## CITY OF PORTLAND

November 28, 2000

RE: 35 Saunders Street 2 legal dwelling units  
CBL: 130-G-009  
Zone: R-5 Zone

Proposed Fire Escape + Deck
Barbara Pearson
35 Saunders Street
Phone 774-7058

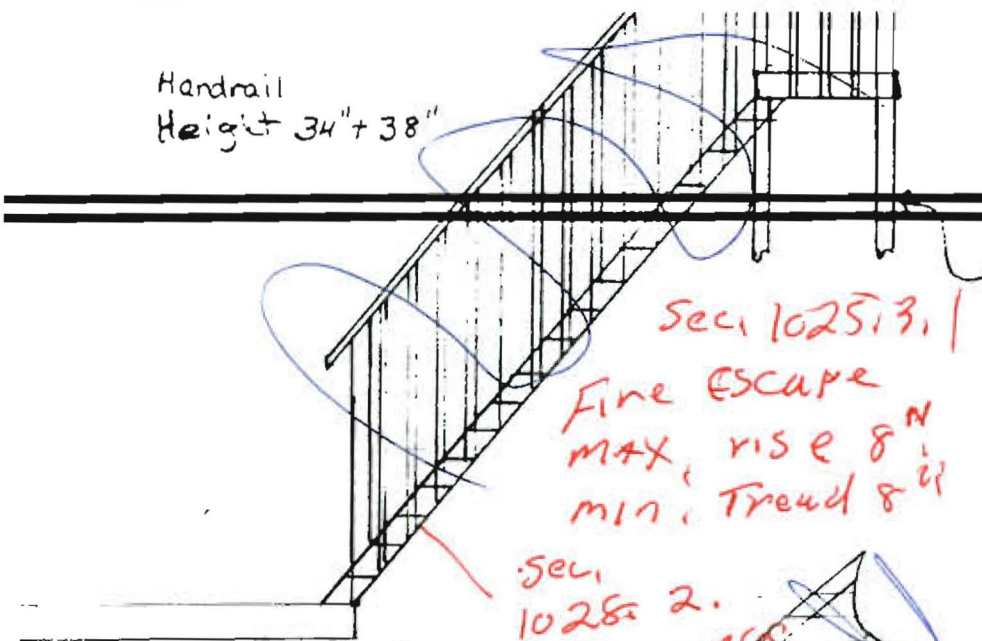
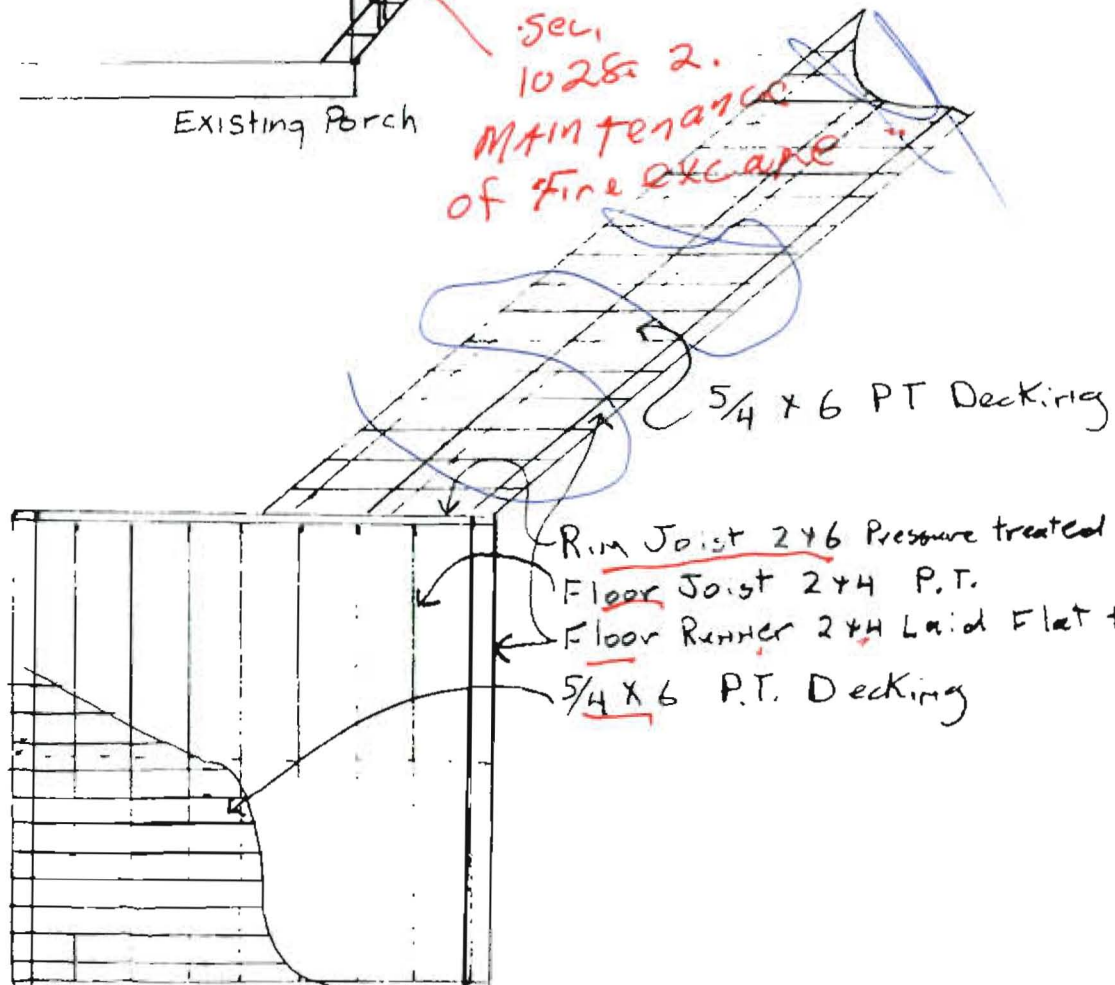
I am in receipt of a permit application to add a 10x10 deck, 3x16 exterior walkway, 3x4 exterior platform and 3x16 open, exterior fire escape. This permit **can not** be issued because it is not meeting the requirements of the R-5 zone. The ordinance specifically states: No open outside stairways or fire escapes above the ground floor shall be constructed.

I would be happy to review this permit again with any new plans which show this exterior fire escape in compliance, such as being enclosed and meeting the current zoning code setbacks.
